INSPECTION REPORT

PROJECT NAME: Ellison St. Office Warehouse

LOCATION: 4000 Ellison St. NE, Albuquerque, New Mexico, 87109

TRACKING NO: NMR1004C1, NMR1004CM

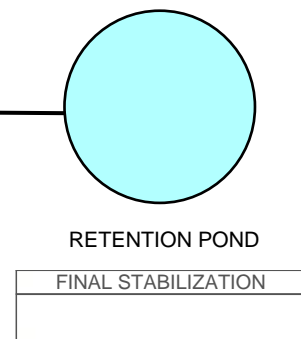
#	S&E/P2 CONTROLS	MAINTENANCE	CORRECTIVE ACTION	LOCATION	QUANTITY	UNIT	PHOTO
1	NPDES Permit Notification	None	None	Entrance	1	EA	Yes
2	Silt Fence	None	Replace	Back perimeter	400	LF	Yes
3	Sanilets	Anchor	None	On site	1	EA	Yes
